Our Ref: LU/93/20/HH
Your Ref:

Town & Country Planning Act 1990 (as amended)
Town & Country Planning (Development Management Procedure) (England) Order 2015
Application for Planning Permission for Works or Extension to a Dwelling

Development Front mono pitch extension enlarging entrance hallway and creating a utility area.
Note All materials to match existing construction.

Location 45 Tideway Littlehampton

Site Plan at 1:500 Scale

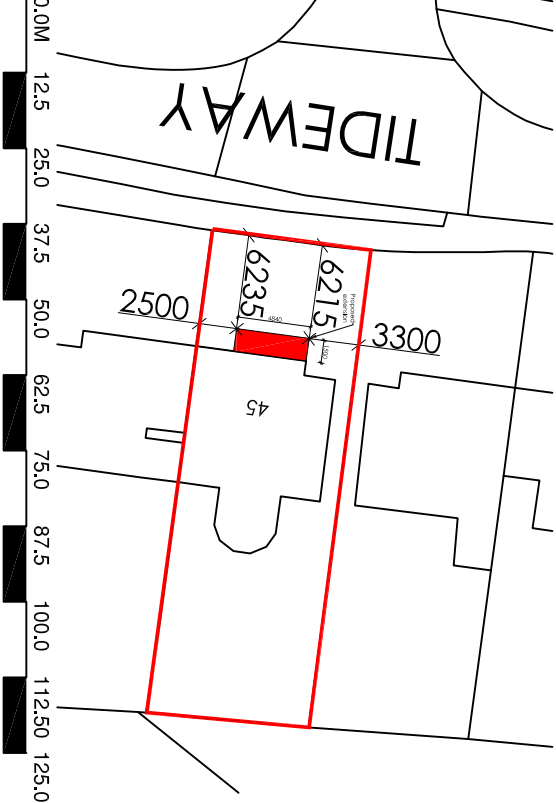
Block Plan: You are required to include dimensions from the proposed extension to all site boundaries.

South Elevation(Part of side)

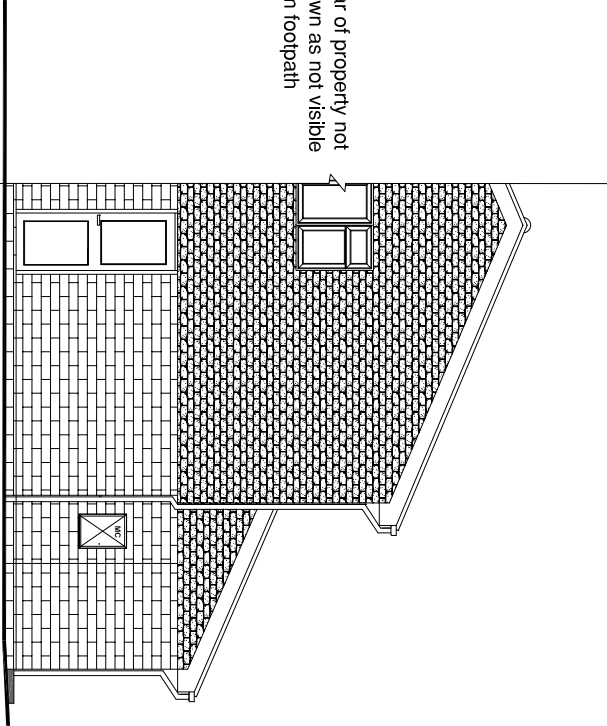
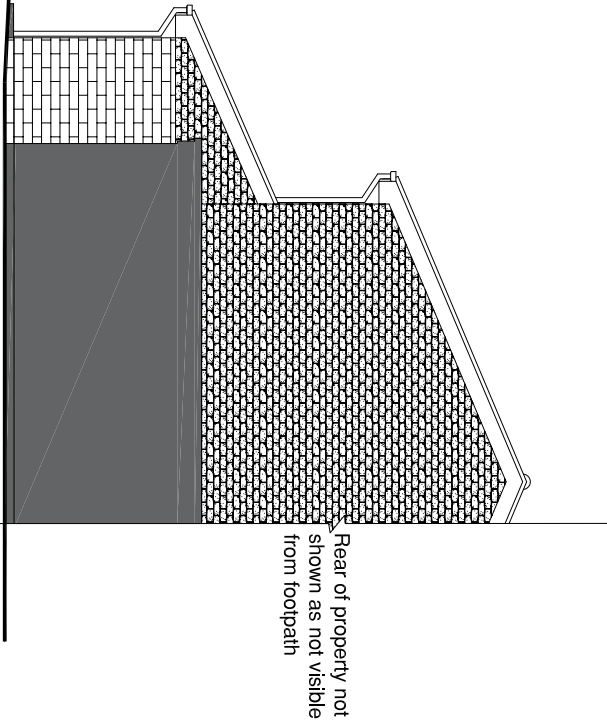
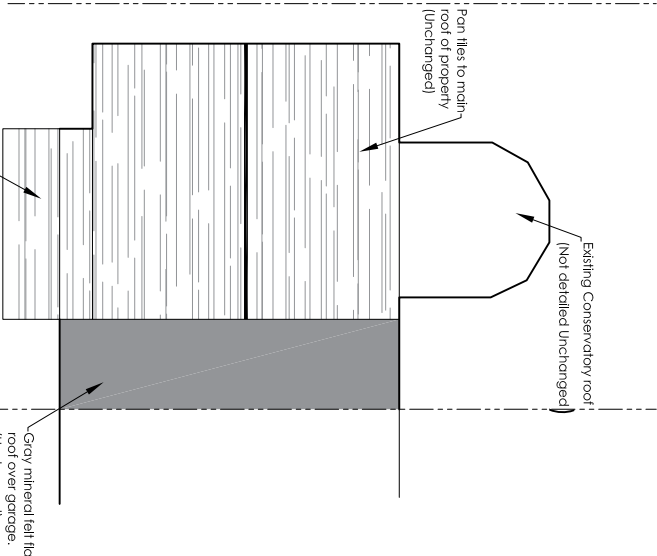
Other Side Elevation: Please provide the other side elevation for this application.
